PERMIT ISSUED		Permit No: 01-1093 OCT 15 2001	Issue Date: 1 5 2001	CBL: 342 A013001
Location of Construction: 69 Maggie Ln (lot #10)		Owner Name: Maggie Lane Development LLC	Owner Address: Po Box 1012	Phone: CITY OF PORTLAND
Business Name: n/a		Contractor Name: Dwight Brackett	Contractor Address: 84 Country Lane Portland	Phone: 2077728629
Lessee/Buyer's Name: n/a		Phone: n/a	Permit Type: Single Family	Zone: R-5

**CITY OF PORTLAND, MAINE
DEVELOPMENT REVIEW APPLICATION
PLANNING DEPARTMENT PROCESSING FORM
Planning Copy**

Approval Conditions of Planning

CITY OF PORTLAND, ME
BOCA 1999 Plan Review Record
One and Two Family Dwelling

| Drawing Name: | Space & Bulk<br>Requirements Lot 10 |

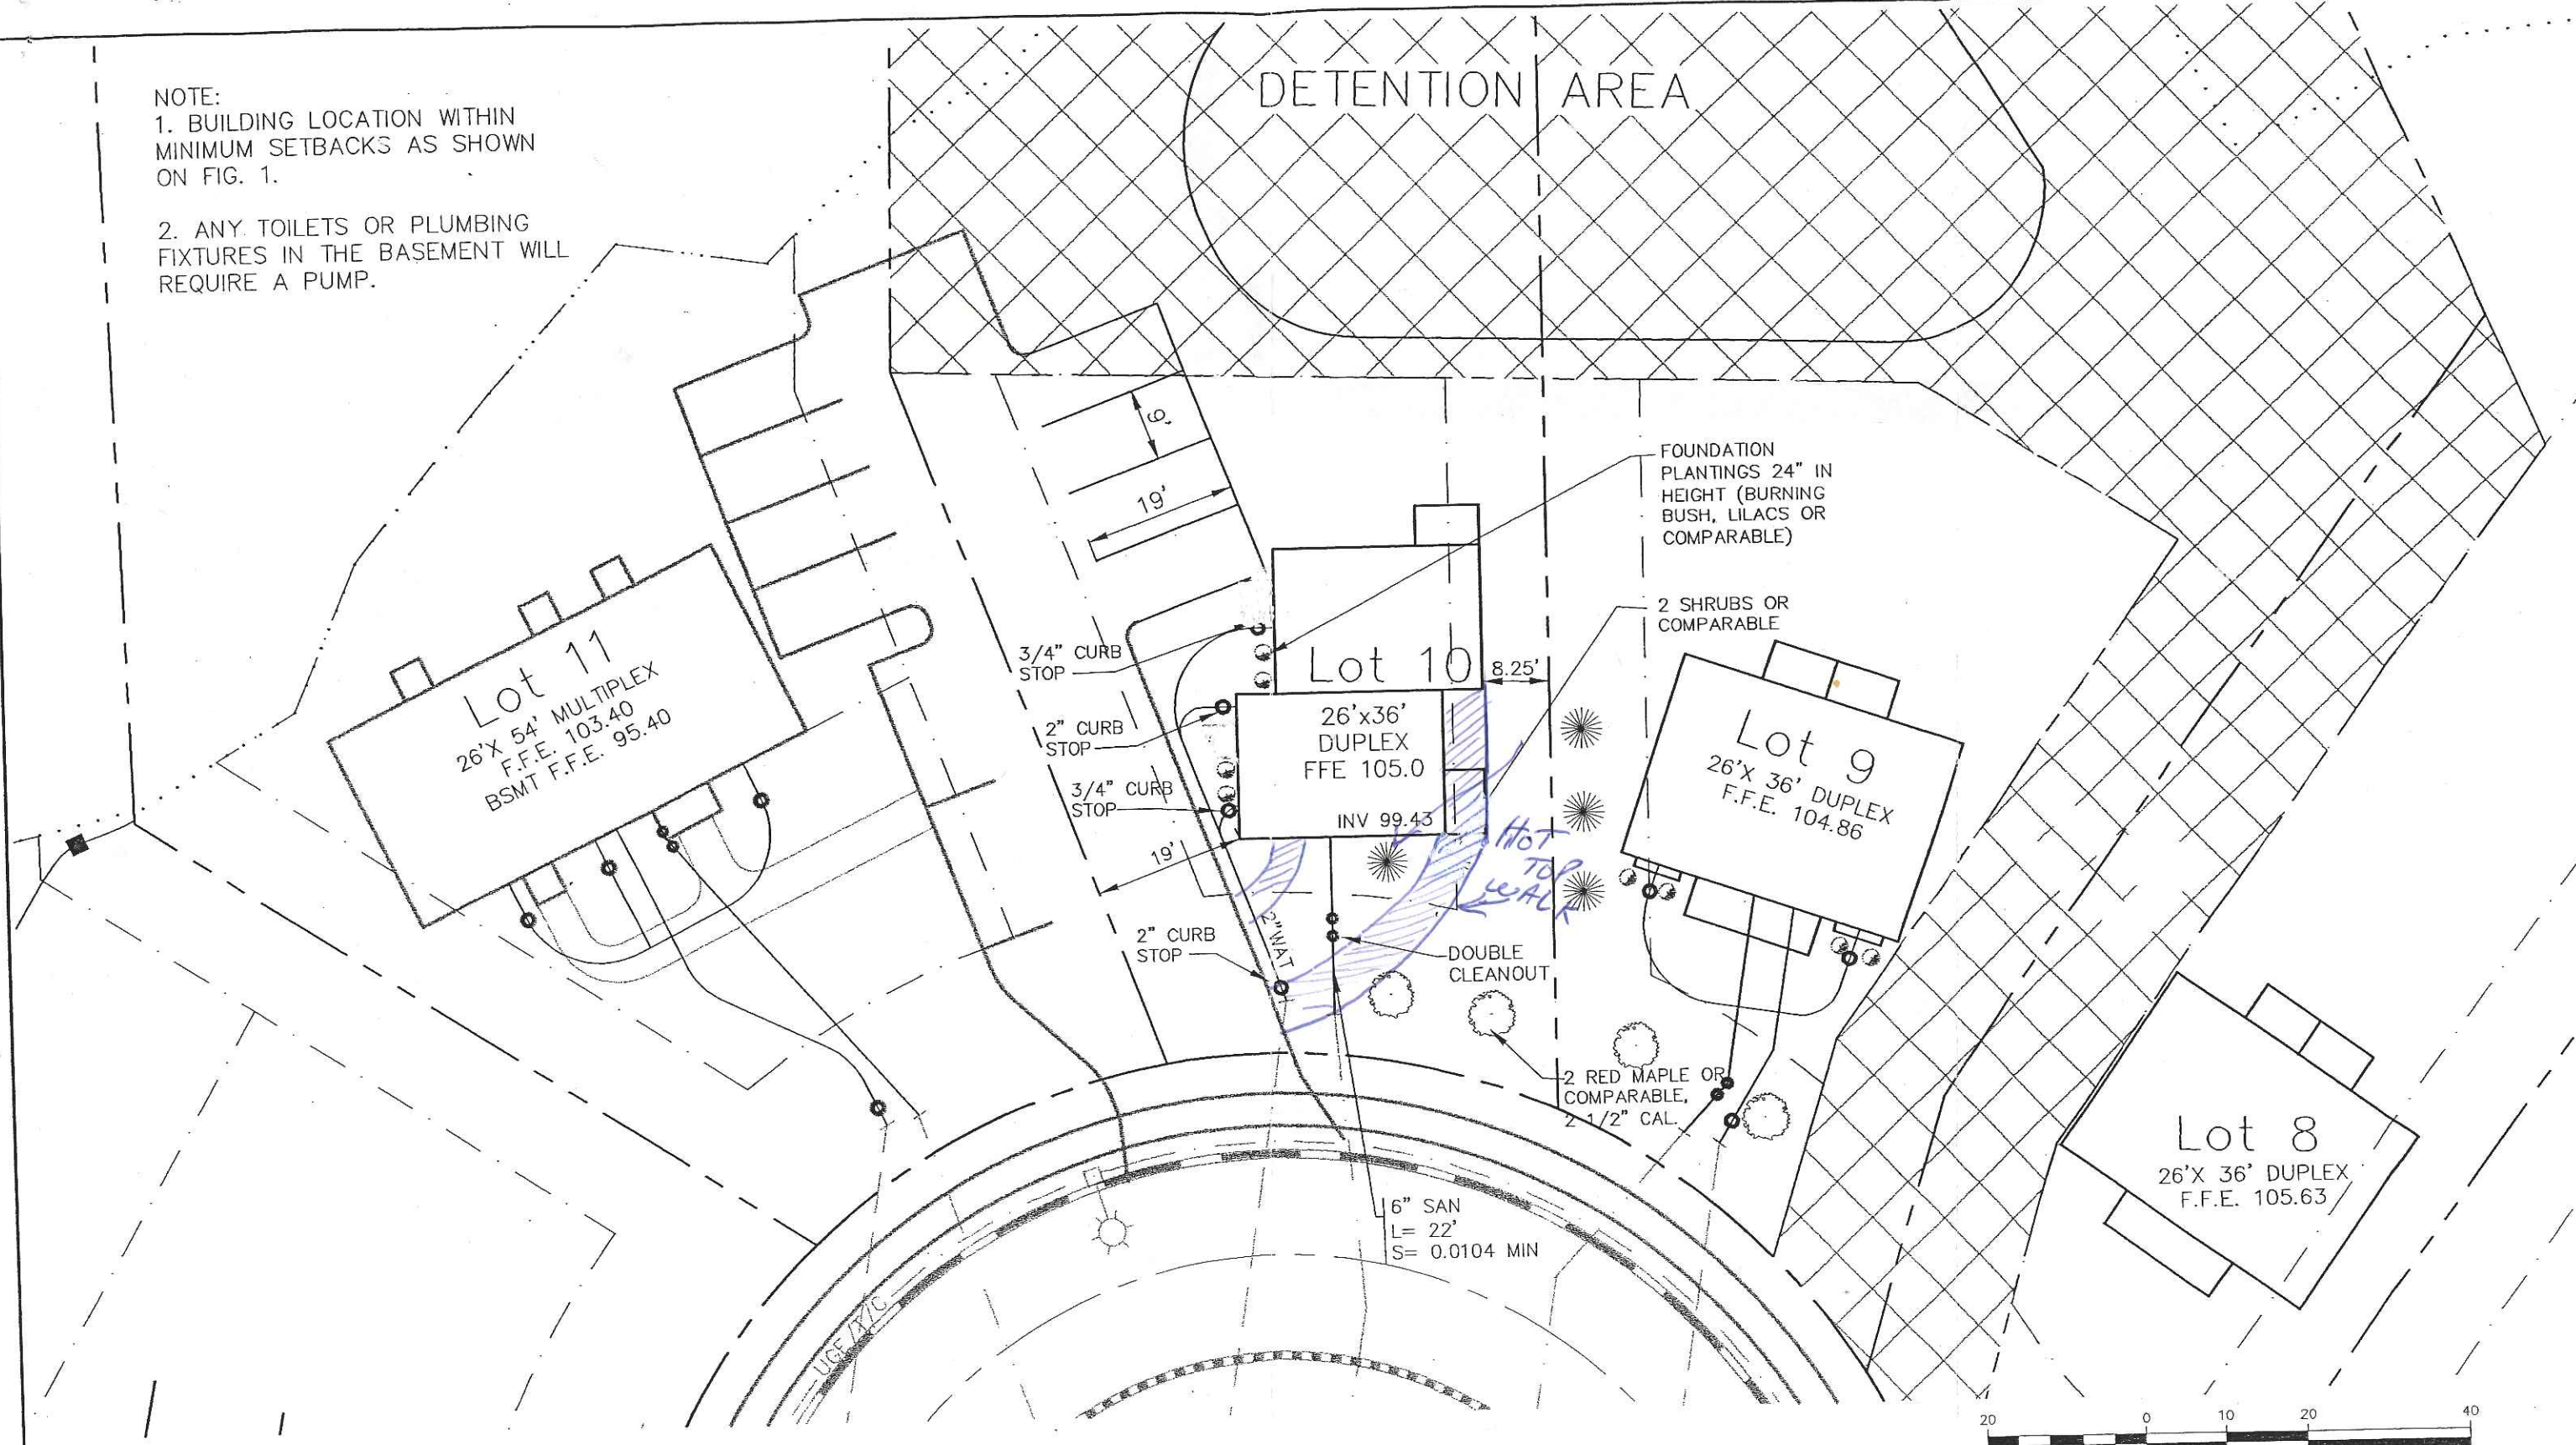
- 1 AMENDED SITE PLAN APPROVAL:
BUILDING LAYOUT CHANGES HAS ALTERED THE ORIGINAL LANDSCAPING.
THE LANDSCAPING REQUIREMENTS (2 TREES PER UNIT, 2 FOUNDATION PLANTINGS PER UNIT) STILL APPLY, AND LOCATIONS SHALL BE FIELD ADJUSTED.
